WEST SUSSEX COUNTY COUNCIL CONSULTATION

TO:	Arun District Council FAO: Amy Myer
FROM:	WSCC - Highways Authority
DATE:	27 April 2020
LOCATION:	Ferringham House, 58 Ferringham Lane, Ferring, BN12 5LU
SUBJECT:	FG/41/20/PL 1 No new dwelling & detached hydrotherapy pool house along with associated external works & creation of 1 No additional vehicular entrance.
DATE OF SITE VISIT:	N/A
RECOMMENDATION:	Advice
S106 CONTRIBUTION TOTAL:	N/A

Proposed Block Plan - 1:500 @ A1

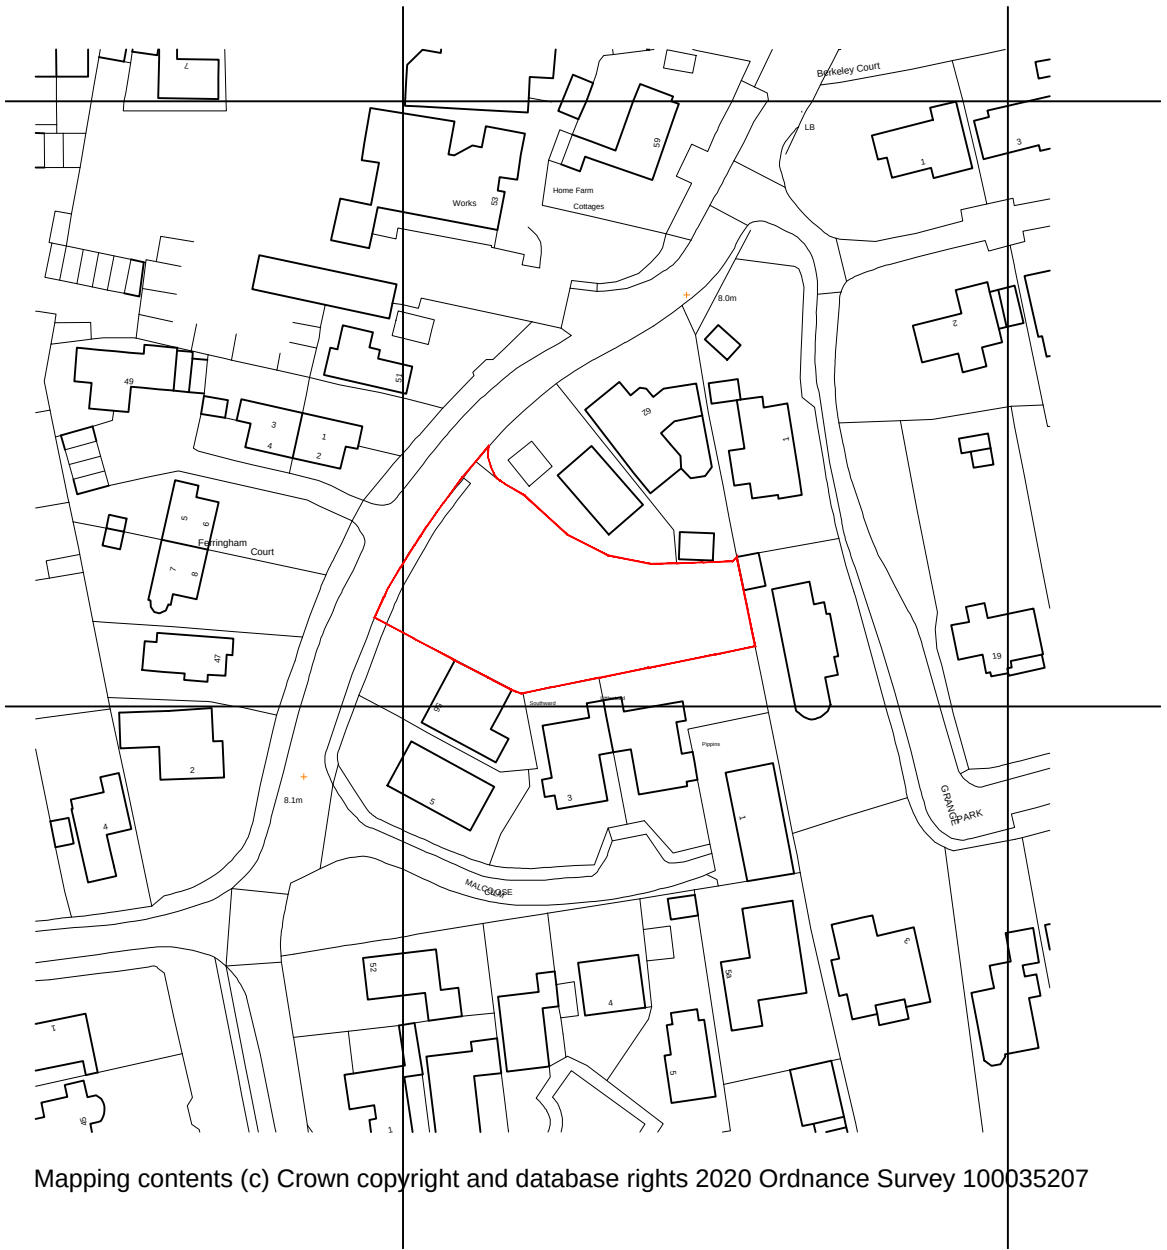
The applicant proposes a second vehicular access off Ferringham Lane, to form an in-out arrangement. The LHA advises the applicant to contact the proprietor of the privately maintained lane, to obtain formal approval for the proposed access works.

The applicant proposes three car parking spaces for this proposal. This includes a double-car garage with internal dimensions of 6m x 8m. Under Arun Parking Standards (adopted January 2020), the LHA would anticipate that three parking spaces would be sufficient for a dwelling of this size and location. As the applicant proposes a double car garage and driveway with space for at least two parking spaces, the LHA is satisfied that the proposed parking provision is in accordance with Arun parking standards.

Residents can utilise the new second access to exit the site in a forward gear.
